From: Simon Davis
Sent: 30 April 2018 15:56
To: 'Jonny Ribbans'
Subject: EG/10/18/DOC - 59 Elm Grove

Comments on Application:

Condition 7 – 'No development including construction activities shall take place unless and until all of the existing trees/hedges to be retained on the site have been protected in accordance with the submitted Tree Retention and Protection Plan dwg.LLD789/02 Rev 00.

Fig.1 – View NE across site entrance

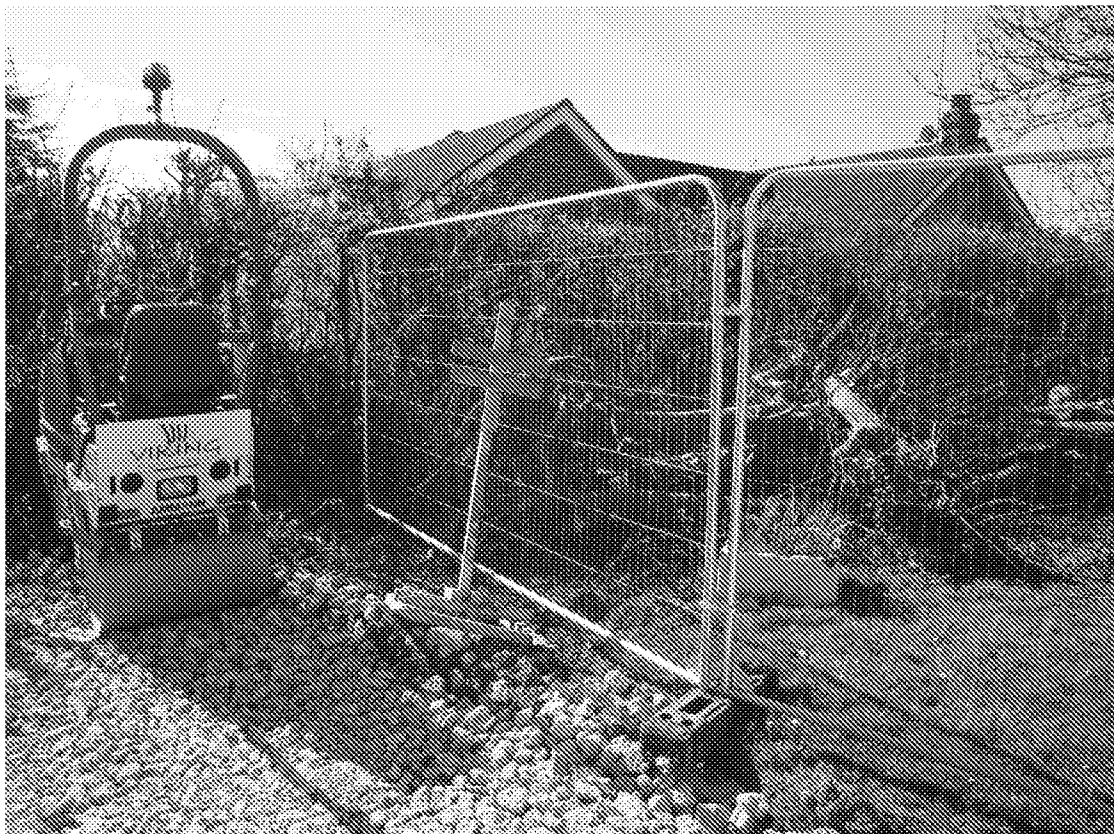
◆ *Tree nos T01, T03 and T08 and mixed species hedgerow around the site entrance have been removed, despite their being identified for retention. Numerous other trees previously identified for removal have been so, thus there is no significant vegetation around this section of the site frontage. This now negates any requirement for the proposed 'No dig' construction North of T1 and installation of Tree Protective Fencing (TPF) around the Root Protection Area (RPA) of T08 as detailed on the plan (figs.1 & 2).*

◆ *TPF is incomplete from the West corner of the existing dwelling and so does not form the required Construction Exclusion Zone (CEZ) around Yew tree T06 (fig.1).*

◆ *ALL the TPF on site does not meet their own stated standard and falls short of the requirements in BS5837. The HERAS panels while clamped together are sat in movable block trays. There are no stabilizing struts or ground penetration of uprights therefore the whole structure can be moved around as it suits and offers little if any resistance to an impact (figs 3 & 4). There is adequate room and surface type to allow for a secure installation, as described.*

◆ *TPF around T25 does not abut the dwelling and therefore does not provide the expected CEZ. There has been mechanical intrusion into the RPA involving deep excavation with associated loss of tree roots, thus negating any requirement for the proposed 'No dig' construction to its North aspect (figs.1 & 5).*

- TPF around T24 is incomplete and does not provide the necessary CEZ (fig.6).

- The developer must now install permanent fencing in accordance with their landscape design plan and as a matter of urgency; to form an effective Construction Exclusion Zone so as to adequately respect and protect significant trees on site before further damage can occur.
